Re: Dell's Nursery Rezone – *Technical Review 1*
PA 22041

RE: Dell's Nursery Rezone, File# PA22-041
Rezone for Warehouse & Mixed Use
4131 104th Street & Parcel # 30051600200200

Preliminary Site Plan

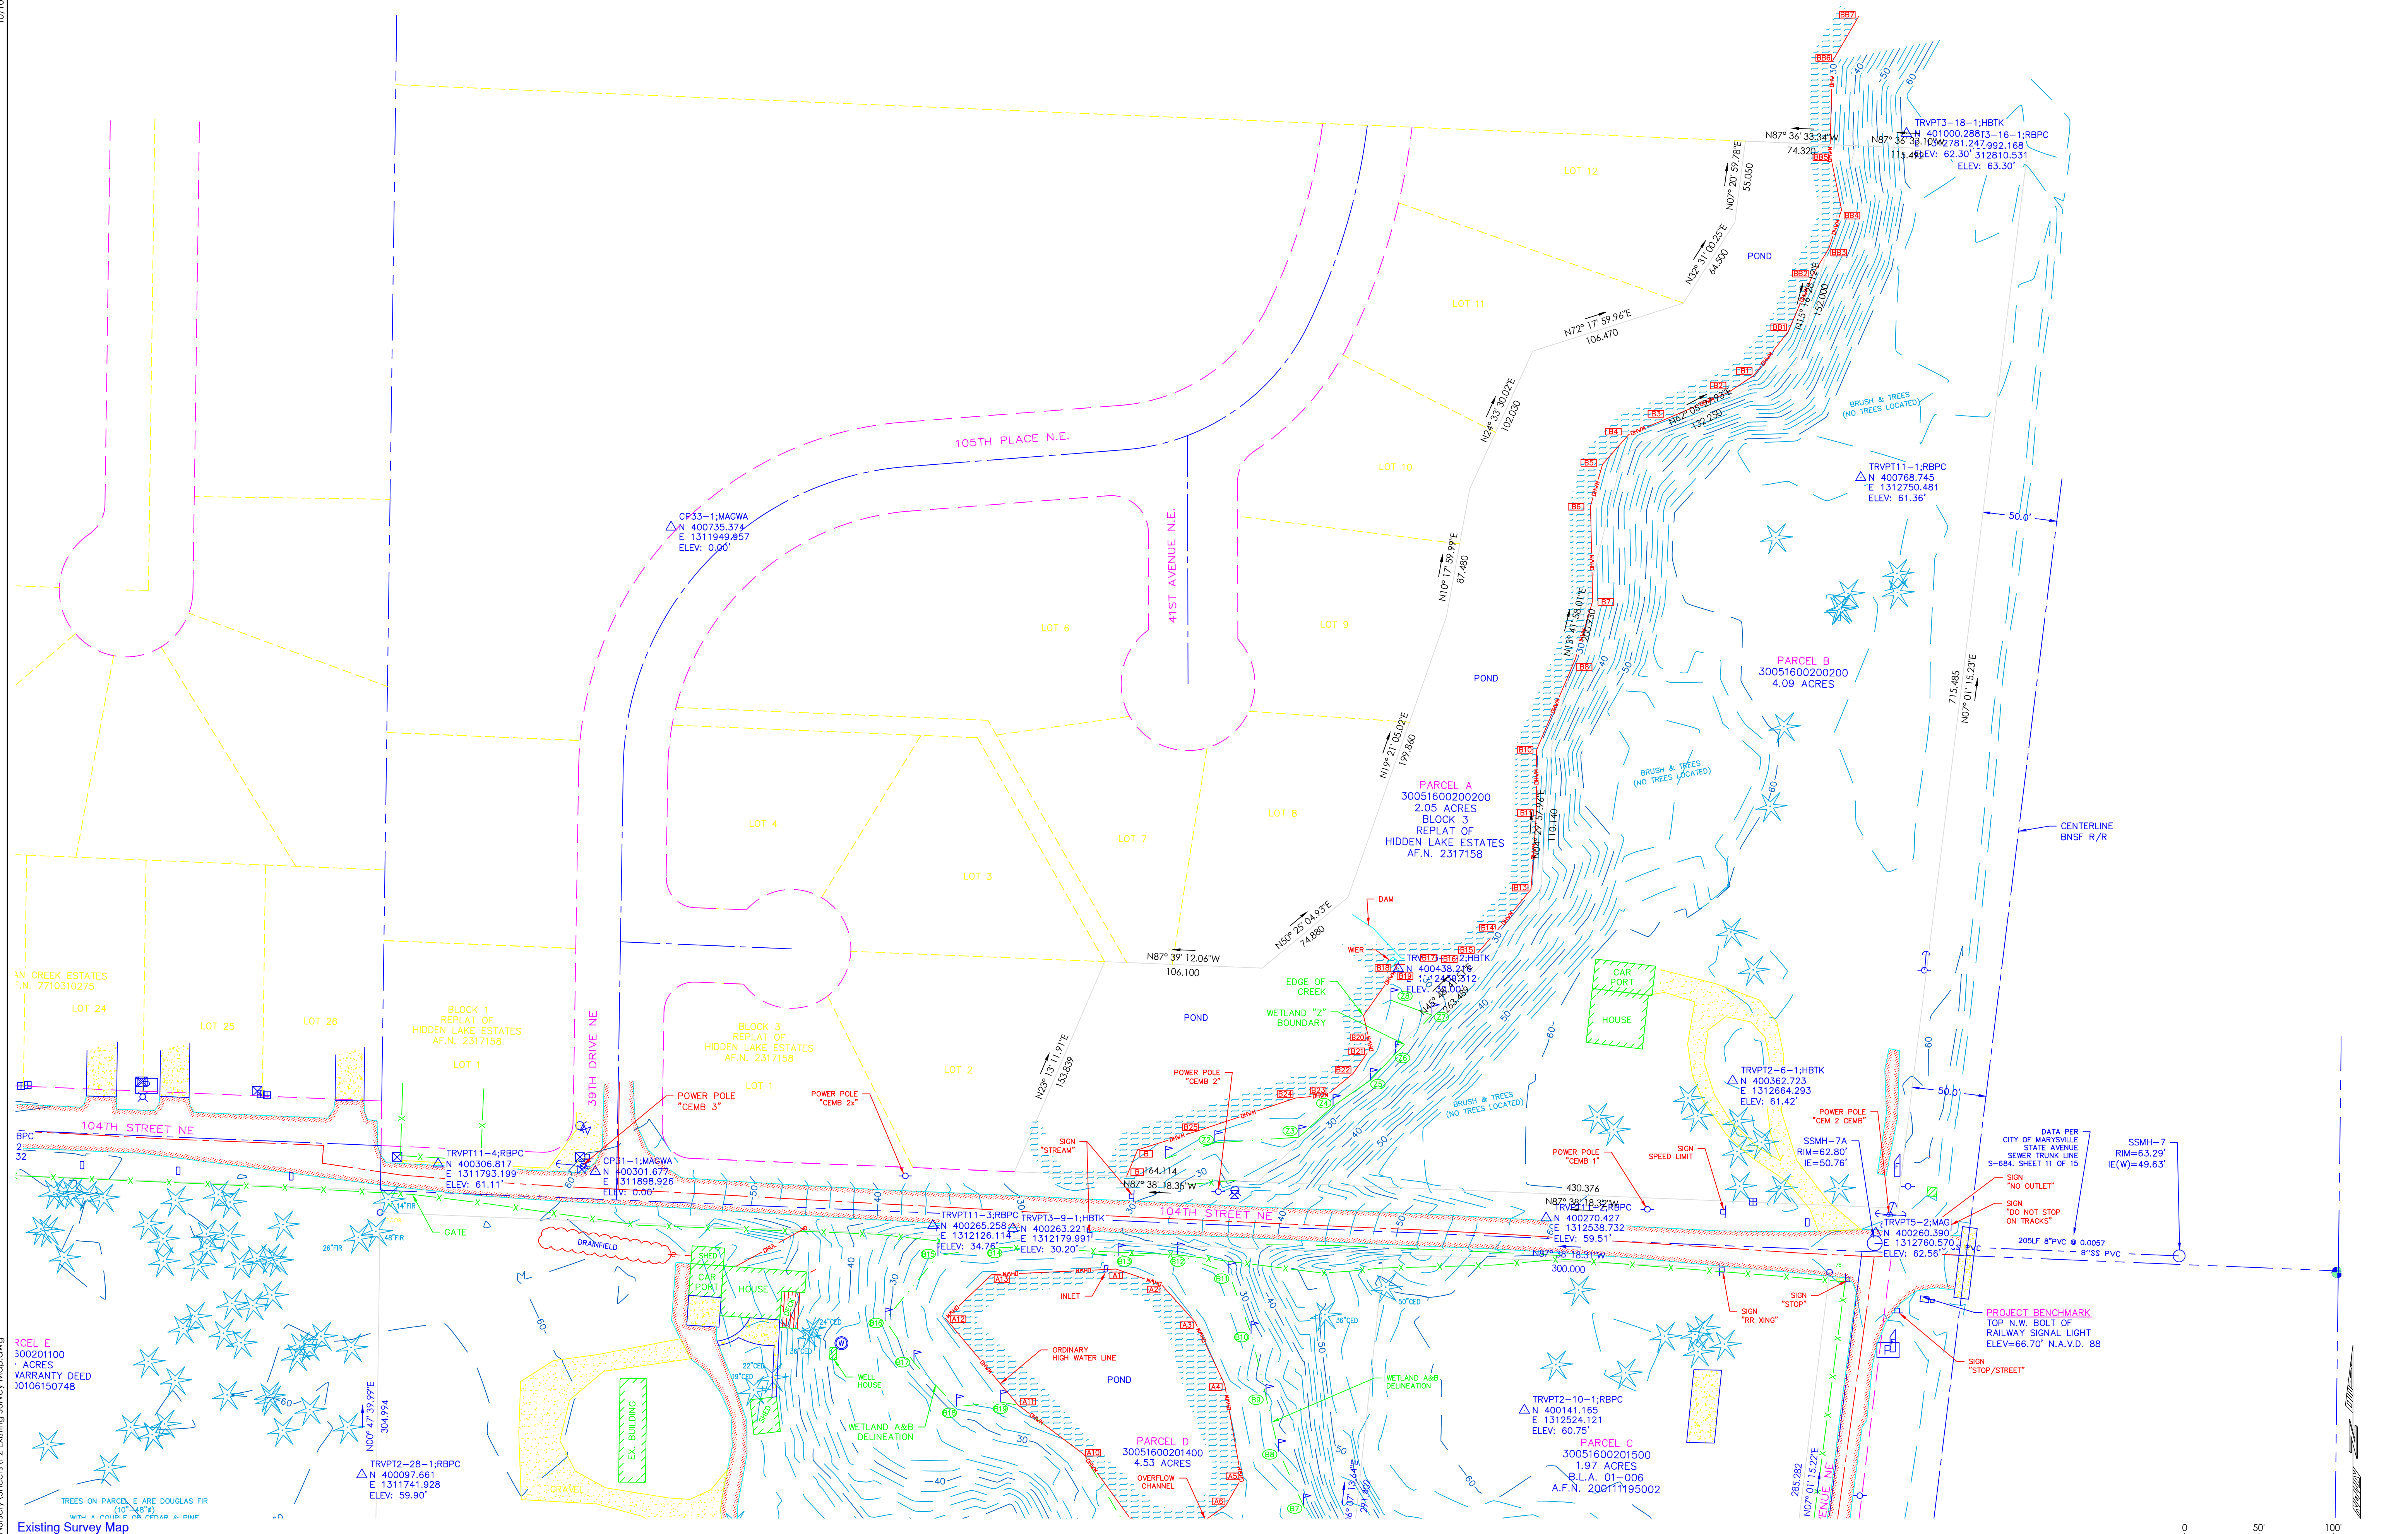
5. Amend Sheet P1, as follows:
 - a. Rows of parking are required to be located no greater than 45' from a minimum 5' wide landscaped island. Parking stalls P19 – P28, P47 – 57 do not comply with this requirement. Additionally, a landscaped island is required on the north side of P44, north and south side of P45 & P46 and north side of P87.

- b. The proposed solid waste collection areas shall be landscaped on the north and south sides with a minimum 5' wide landscape island.
 - c. Provide bicycle parking calculations in accordance with MMC 22C.130.060.

- d. Provide carpool parking calculations in accordance with MMC 22C.130.030(3).
 - e. Provide a detail of the required carpool parking signage. Signs must be posted indicating these spaces are reserved for carpool use before 9:00 a.m. on weekdays.
